MEMORANDUM

TO: Nell Donaldson, Planner
FROM: David Senus, PE
DATE: October 27, 2015
RE: AC Hotel, Preliminary Level III Site Plan Application

Woodard & Curran has reviewed the Preliminary Level III Site Plan Application for the proposed hotel located at 158 Fore Street in Portland, Maine. The project involves the construction of a new building to provide hotel rooms, retail space, and residential condominiums.

**EXISTING
 CONDITIONS PLAN**

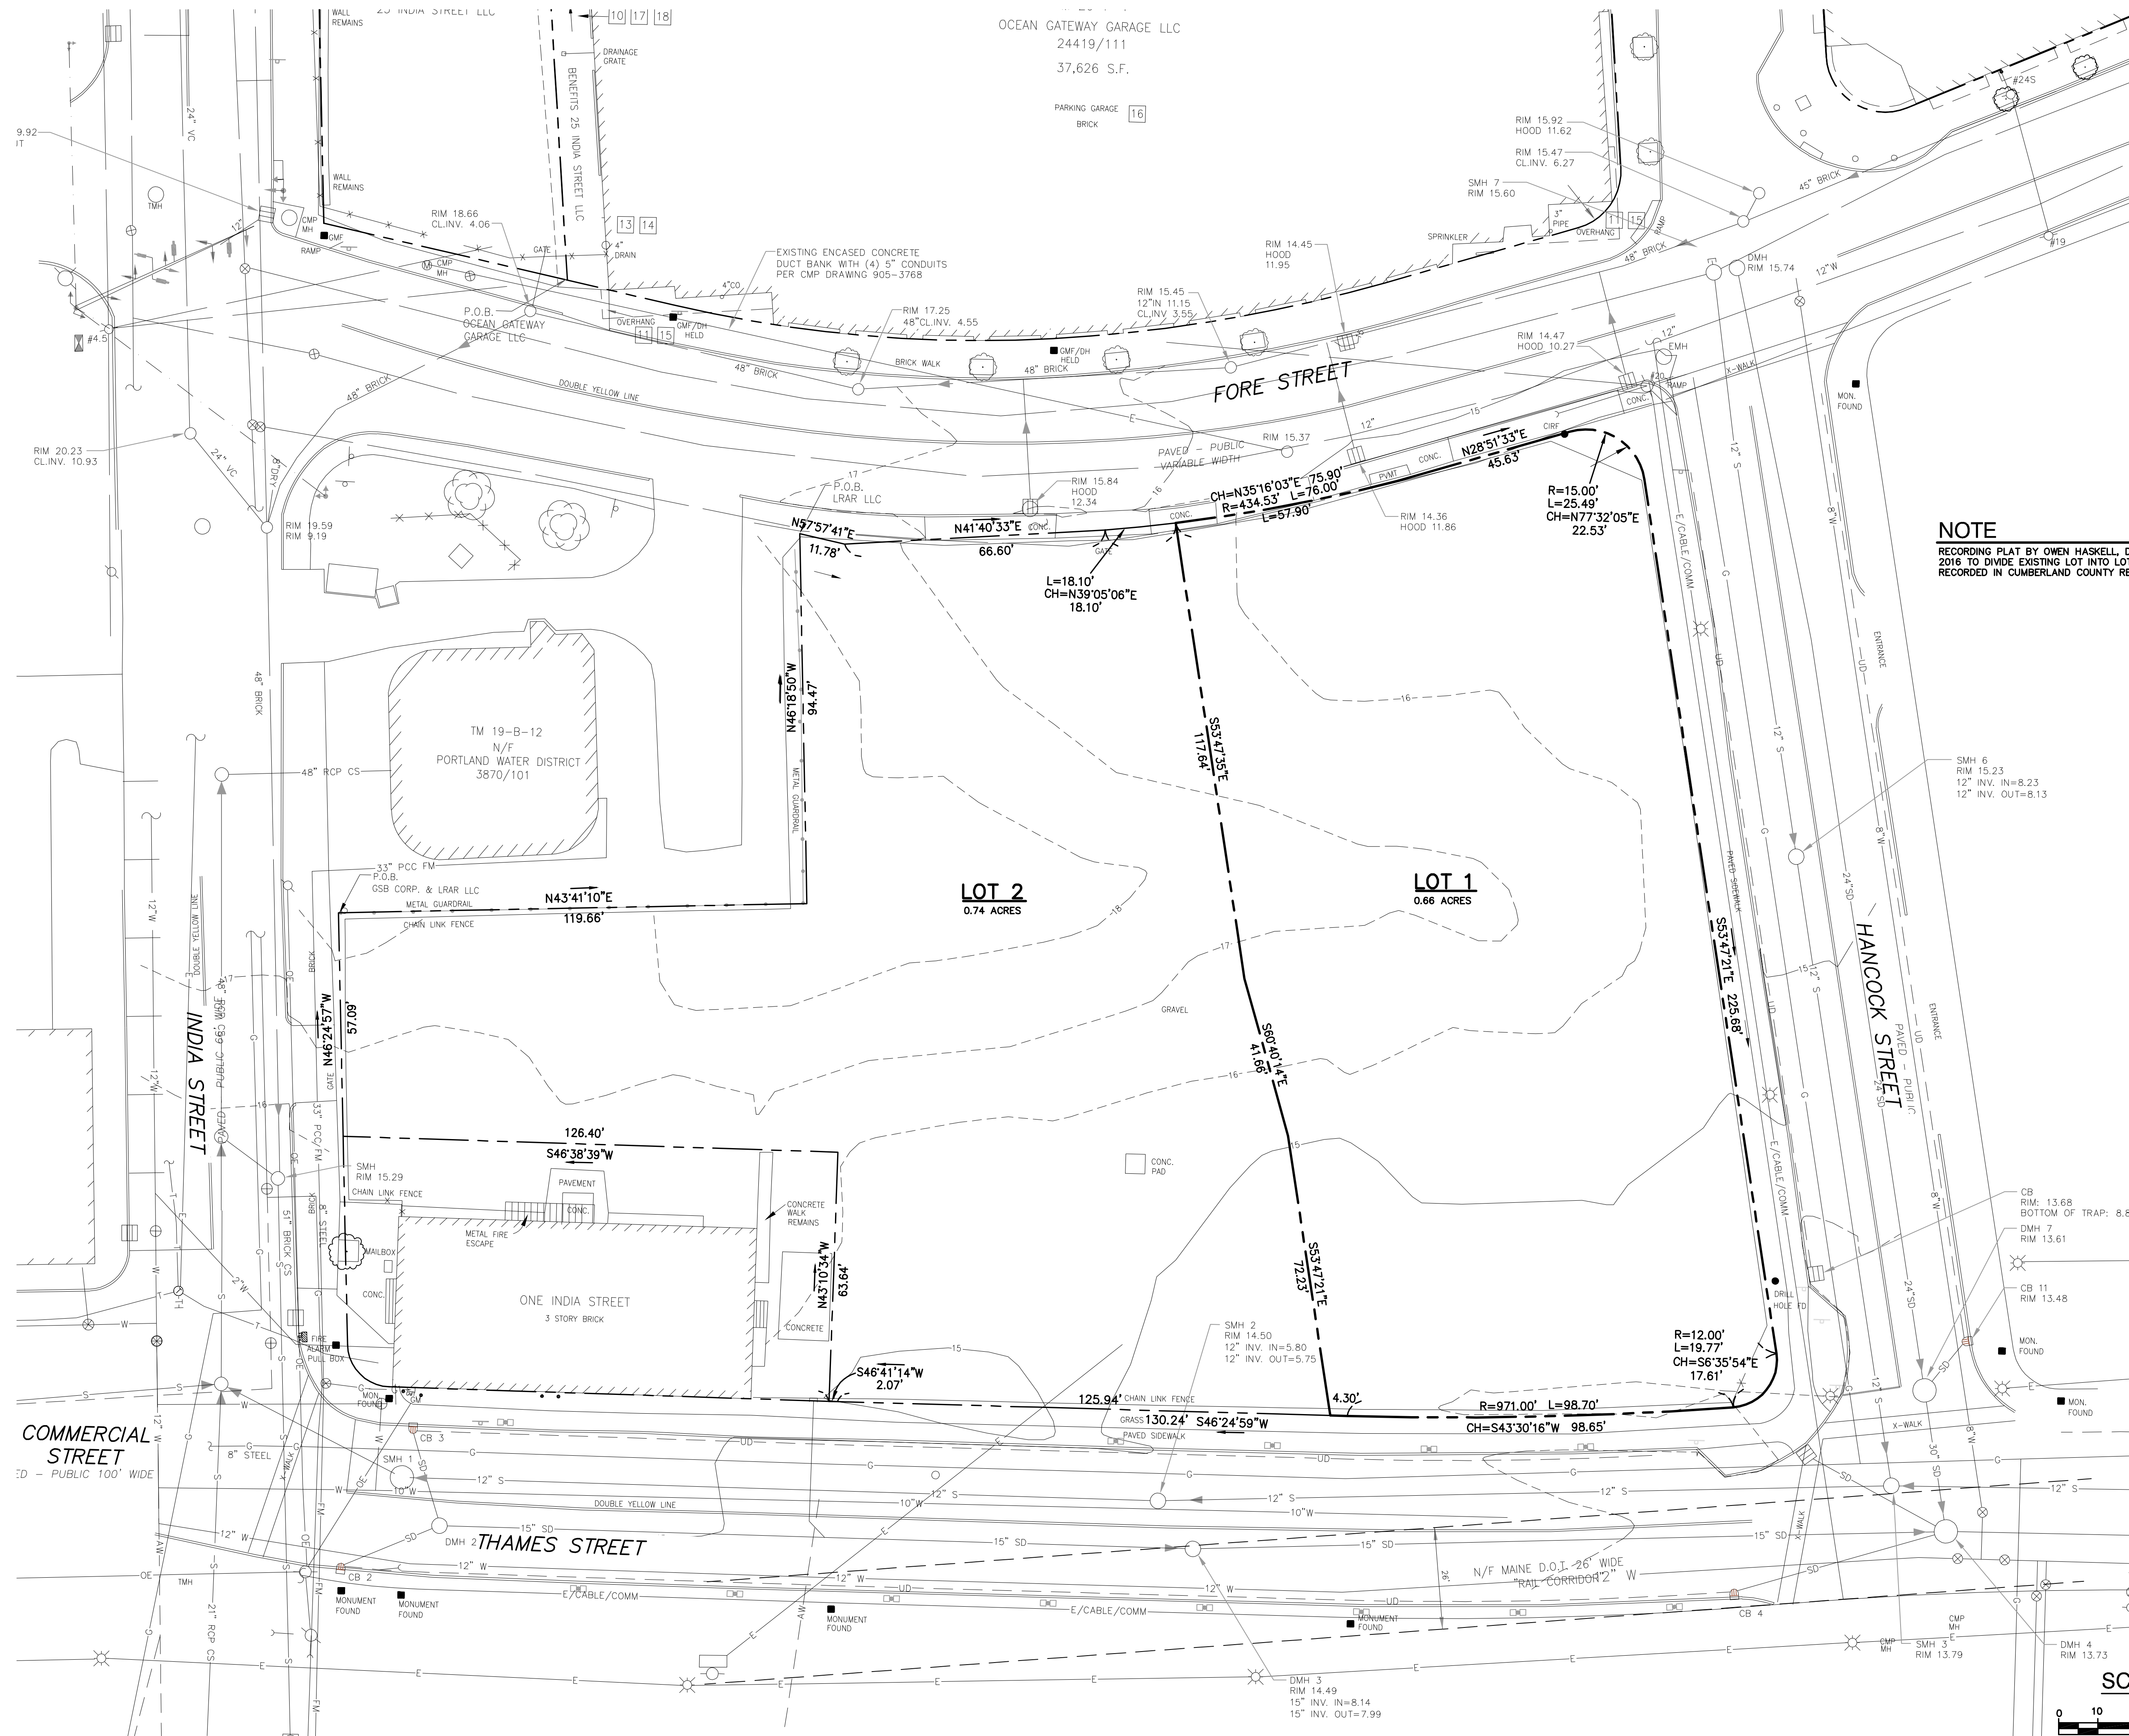
- a) Vertical Granite Curb;
 - b) Brick Sidewalk;
 - c) Brick Driveway Apron; and
 - d) ADA Pedestrian Ramps.
- 9) Sheet C-0.1 – Existing Conditions Plan – The existing conditions plan should show existing utilities in the adjacent roadways.

UTILITY PLAN

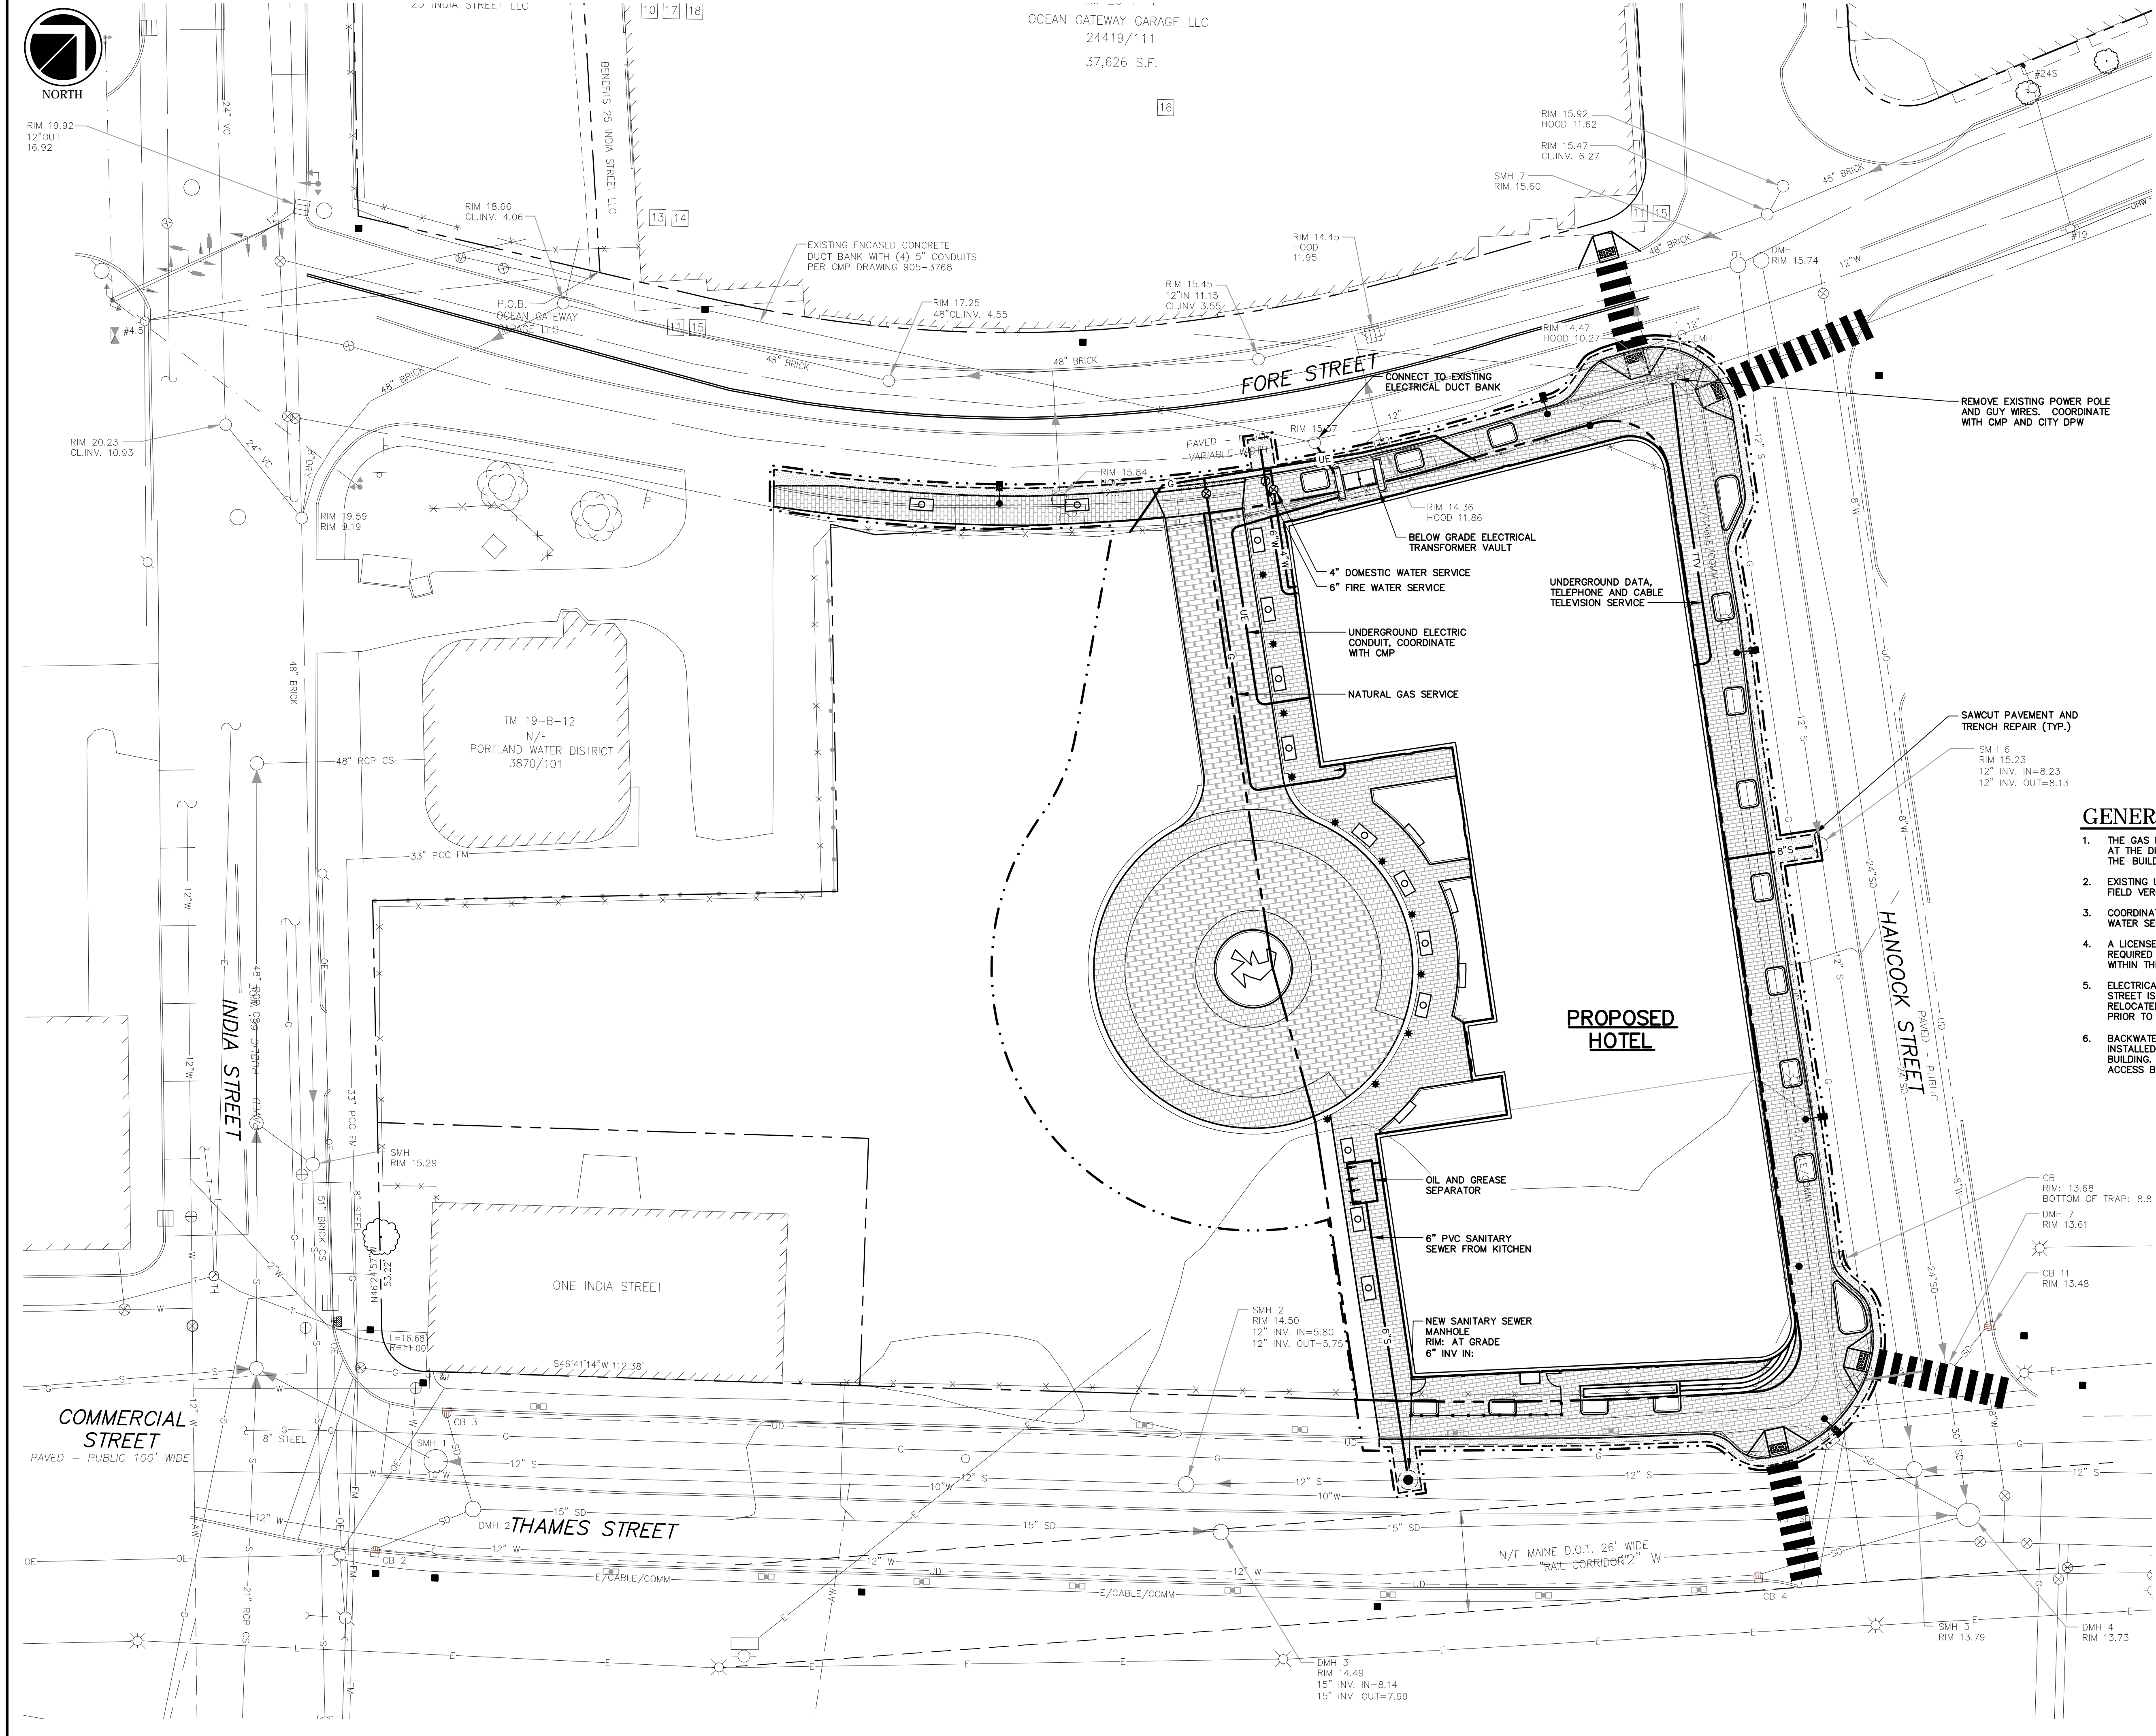
- 10) Sheet C-1.1 – Utility Plan
 - a) Two existing catch basins are shown in the sidewalk (CB5 & 10) at the intersection of Hancock and Thames; however, no catch basins exist in the sidewalk in this area.

- b) A catch basin exists at the apex of the radius (in the crosswalk) at the intersection of Hancock and Thames; however, this structure is not noted on the plans.

- c) Three catch basins exist along the proposed reconstructed curb line in Fore Street, these structures should be reconstructed as part of the project.

- e) The 1,500 gallon grease trap in the Hancock Street roadway ROW appears to conflict with an existing electrical/communications duct bank.
 - f) Utility saw cuts/trench limits should be depicted on the plans.

- g) Water services should be coordinated with the Portland Water District; we would anticipate that a domestic and fire protection service will be required with valves on each.

- h) The “Below Grade Electrical Transformer Vault” is depicted on Lot 1-2 of the subdivision. There is no easement shown for this vault on the subdivision plan. The location of the vault may conflict with future development plans for this lot.
